STATE OF WASHINGTON
DEPARTMENT OF ECOLOGY

November 13, 2023

RE: SP-23-00009

Thank you for the opportunity to comment on the Notice of Application for the Bowers Road Short Plat. We have reviewed the application and have the following comments.

BOWERS ROAD SHORT PLAT
 PART OF SECTION 26, T. 18 N., R. 18 E., W.M.
 KITTITAS COUNTY, WASHINGTON

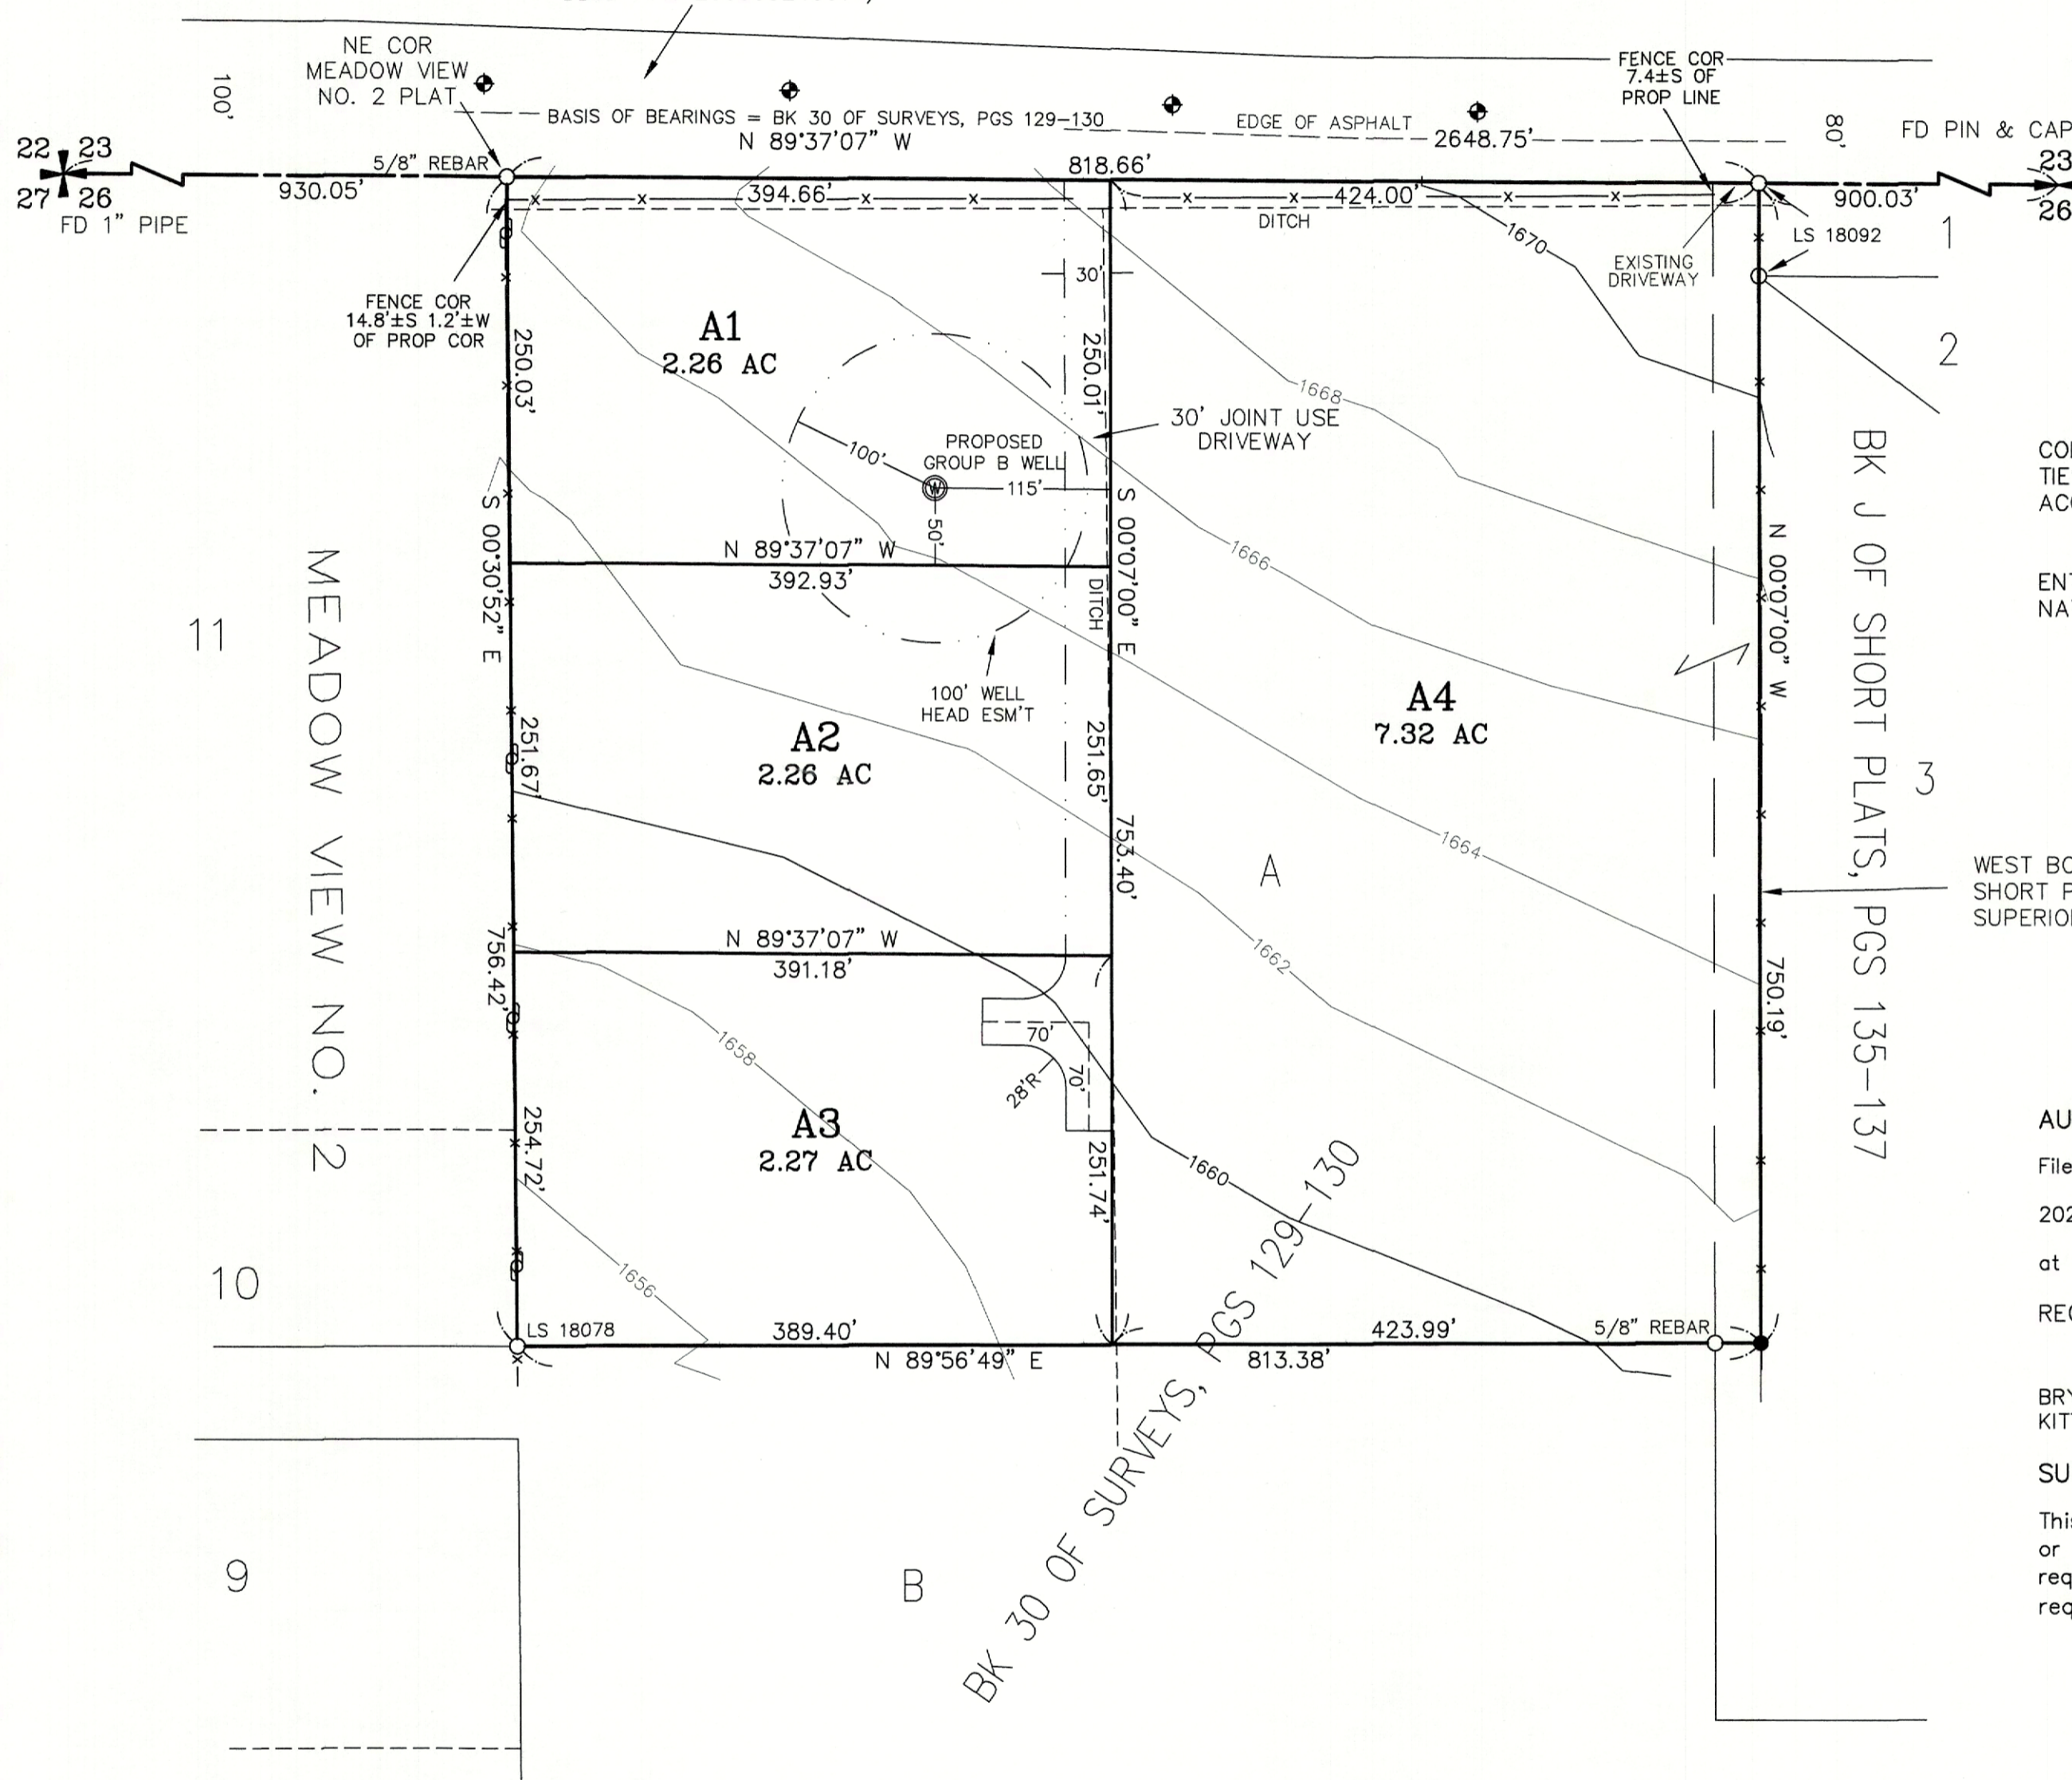
The application package presented a Wetland Inventory Report dated December 10, 2006. Aerial photos indicate wetlands likely remain. Kittitas County Code 17A.01.080 requires critical area reports less than 5 years old. Prior to ground disturbing activities a new wetland determination, delineation, and rating must be completed by a qualified professional. Kittitas County Code 17A.01.080 lists the following minimum report contents:

Wetland Delineations must be conducted according to the 1987 Army Corps Wetlands Delineation Manual and the Arid West Regional Supplement. Each wetland should be rated using the Washington State Wetland Rating Guidance for Eastern Washington 2014 Version. Please reach out to Ryan Anderson at 509-379- 1917 or rand461@ecy.wa.gov with any questions.
